Our ref: AE/2018/122585/01-L01
Your ref: TR030003
Date: 20 March 2018

APPLICATION BY PORT OF TILBURY LONDON LIMITED FOR AN ORDER GRANTING DEVELOPMENT CONSENT FOR A PROPOSED PORT TERMINAL AT THE FORMER TILBURY POWER STATION (TILBURY 2) - WRITTEN REPRESENTATIONS. FORT ROAD, TILBURY, ESSEX, RM18 7NR

ENVIRONMENTAL STATEMENT APPENDIX 16C WATER FRAMEWORK DIRECTIVE ASSESSMENT - CULVERT LOCATION PLAN

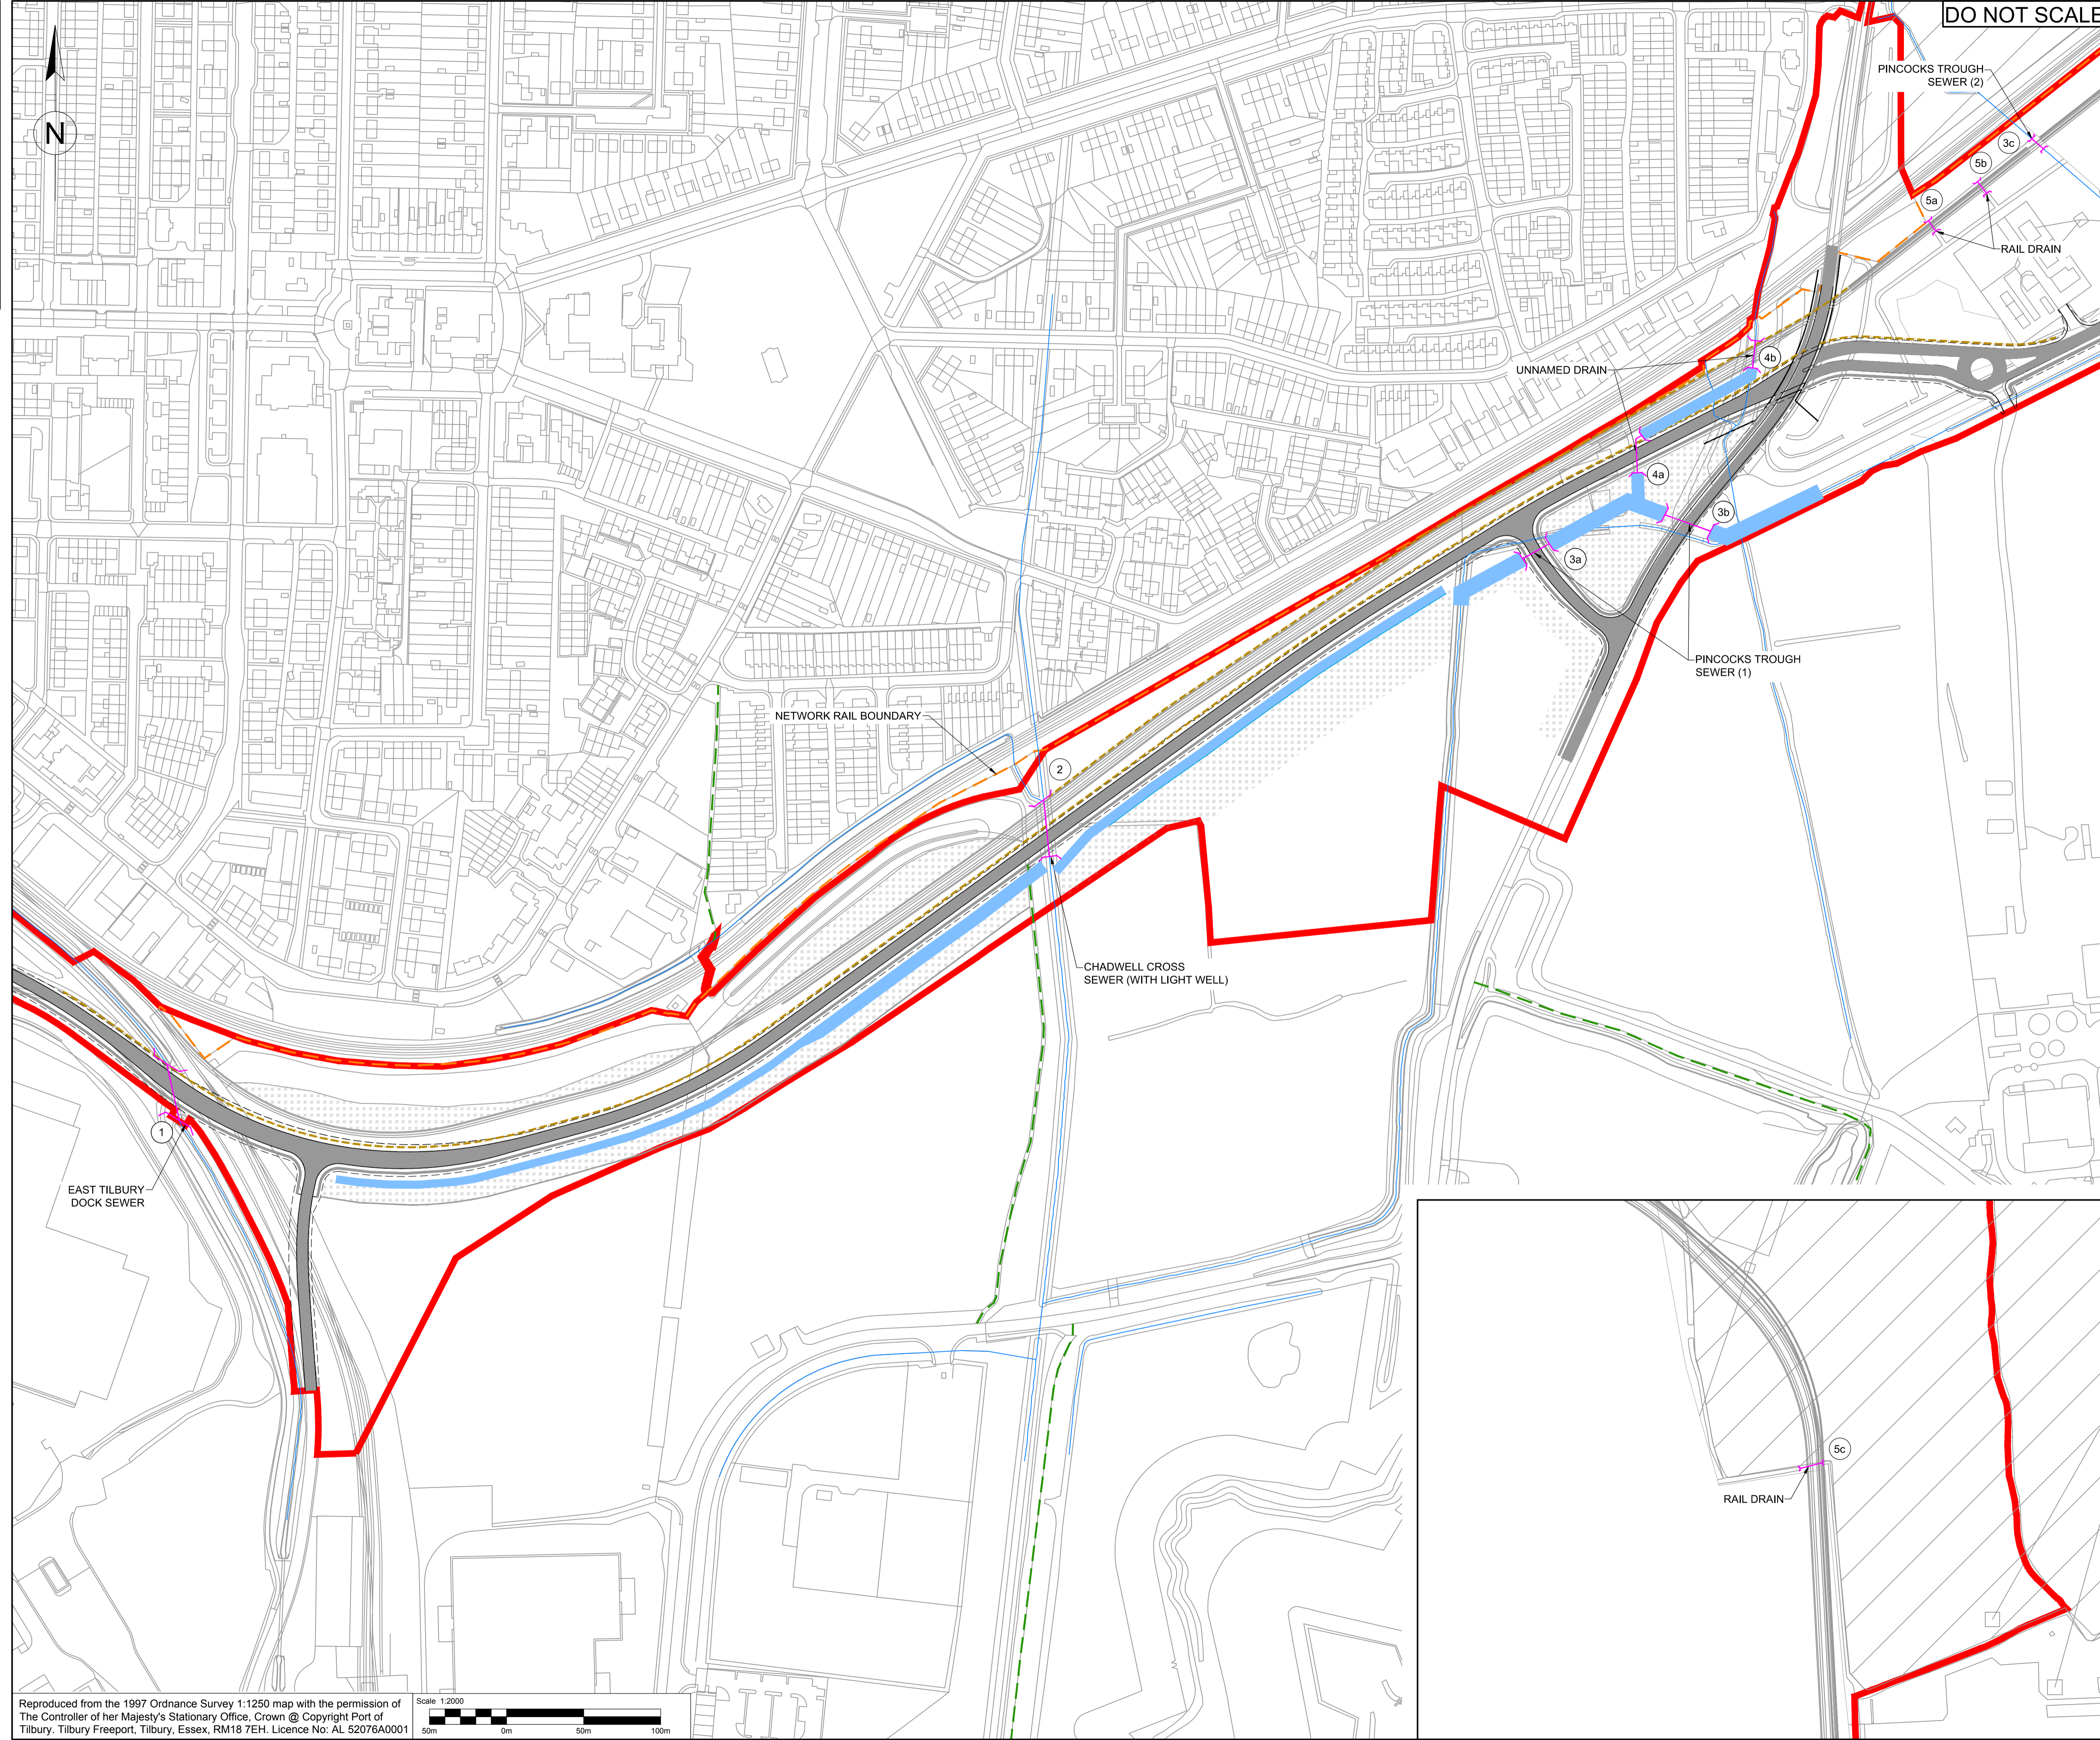
5.1 Section 6.2 of the FRA states that it is recommended that the proposed new culverts for the Chadwell Cross Sewer and East Tilbury Dock Sewer will be 'suitably sized, so they can accommodate peak flows, including allowances for climate change in accordance with our latest guidance'. However Section 3.3.1 on climate change states that the FRA will not undertake any fluvial modelling of the existing surface water drainage network as there is no history of fluvial flooding in the area for development, and that reference has therefore been made to the Tilbury Integrated Flood Strategy. Therefore it is unclear how the culverts will impact on flood risk.

5.2 The applicant will need to provide cross sections of both the existing and proposed culverts to show that they are using the largest possible diameter of culverts that will fit the watercourse. There should be no reduction in the size of the culverts to ensure that the capacity to carry peak flow is maintained and where possible enhanced. Further the applicant will need to show where water will flow if capacity is exceeded or if the culvert becomes blocked. They need to clearly show

5.4 We had discussions with the applicants, where they suggested that the culverts should be sized to be no smaller than existing culverts on the watercourses. We informed them that the culverts should be the largest size that can be accommodated within the watercourse, as an existing inadequately sized culvert should not be used as a reason to allow further inadequately sized culverts, as they can increase the risk of blockage as well as reducing the usual capacity of the watercourse and so increasing offsite flood risk. Also since runoff may enter the watercourse between the inadequately sized culvert and the proposed culvert, the inadequately sized culvert should not act as justification for further similar sized culverts downstream. We also reiterated that the FRA should show the location of exceedence flow paths should there be a blockage of the culvert, and demonstrate that the exceedence flows would not increase flood risk to property. If this cannot be demonstrated then the proposed culvert should be modelled. We are willing to review any plans related to the culverts as they are produced.

8.5 We welcome the intention to retain water voles on the site and to include mammal shelves within the proposed culverts of the re-routed rivers. Cross sections of watercourses and plans are needed to ensure that the biodiversity function of drainage ditches is maximised. The developer should produce detailed designs for the concentric rings of open ditches needed to provide enhanced water vole habitat. The phasing of habitat creation for water voles needs very careful consideration otherwise it may fail due to inadequately established vegetation around the new ponds. A phasing plan should be produced detailing how these concerns may be addressed. This approach has been agreed through the statement of common ground (section - 5.)

9.7 The WFD assessment is satisfactory from a terrestrial habitat perspective. Natural channel design is to be specified, and designs of diverted ditches will need to be provided before the application is determined. This approach has been agreed through the statement of common ground (section – 5.). Compensation is provided matching watercourse length and number of ponds, but ideally enhancements should be sought for a development of this scale with greater length of watercourse and number of ponds established. The design of watercourses and ponds should also be exemplary and provide better habitats than those destroyed to aid with offsetting. This approach is agreed in the statement of common ground (section - 5). With regards to the proposed culverts, mitigation measures are proposed and these are acceptable. We require further detail on fish passage measures, the applicant should consider the use of flaps which don't restrict fish and eel passage in the same way as other sluice designs. We are willing to comment on any plans regarding eel passages as plans become available.
